From: Ross Leal
Sent: 26 February 2018 11:31
To: Planning.Responses
Subject: FW: Planning Consultation on: LU/1/18/PL

APPLICATION LU/1/18/PL

Site Address: 53 East Street Littlehampton BN17 6AU

Description of Works: Two storey extension. This application affects the character & appearance of the East Street Conservation Area & may affect the setting of Listed Buildings.

| East Street Dental Surgery | Extension at<br>53 East Street,<br>Littlehampton, BN17 6AU | Alternative Proposed Elevations | Sept 16    | pd             | 0228 / 104 | -        |

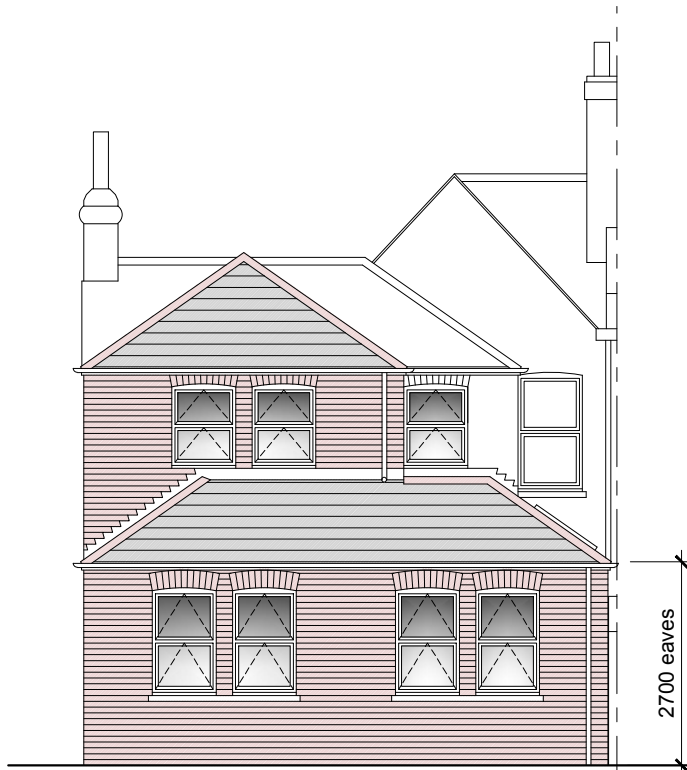
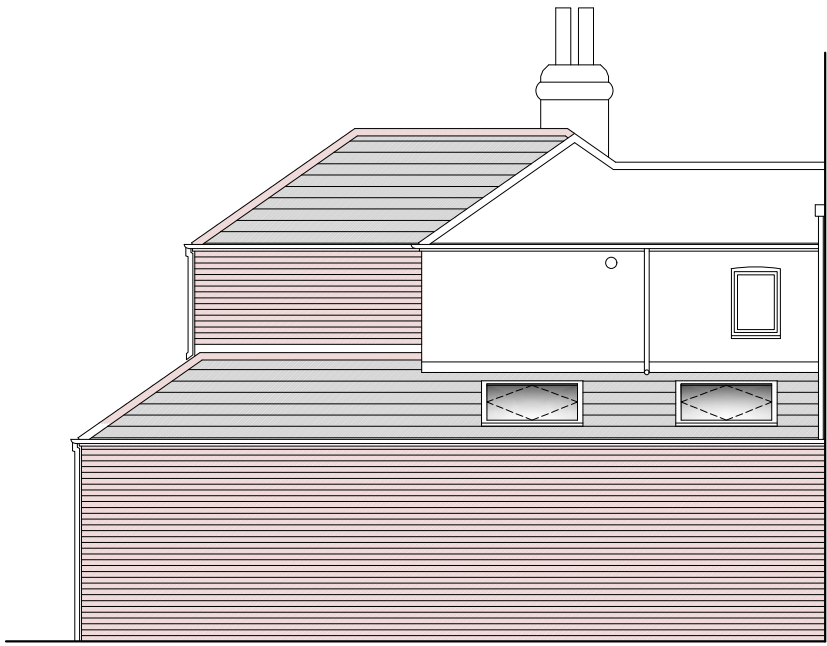
The proposed extension is considered to be dominating to the host building in terms of scale and massing. It would be visible from the public realm, notably the footpath to the East of the range of buildings. However, the proposed does not project further than the adjacent property, Number 47.

Although the proposed fitting of top-hung casement style upvc windows to match existing is described, and given the overall dominance of the proposed to the host building, it is considered that the proposed development would harm the non-designated heritage asset.

It is preferred that other alternatives be sought eg a single storey extension to the dentists' with the rest of the building remaining unadulterated.
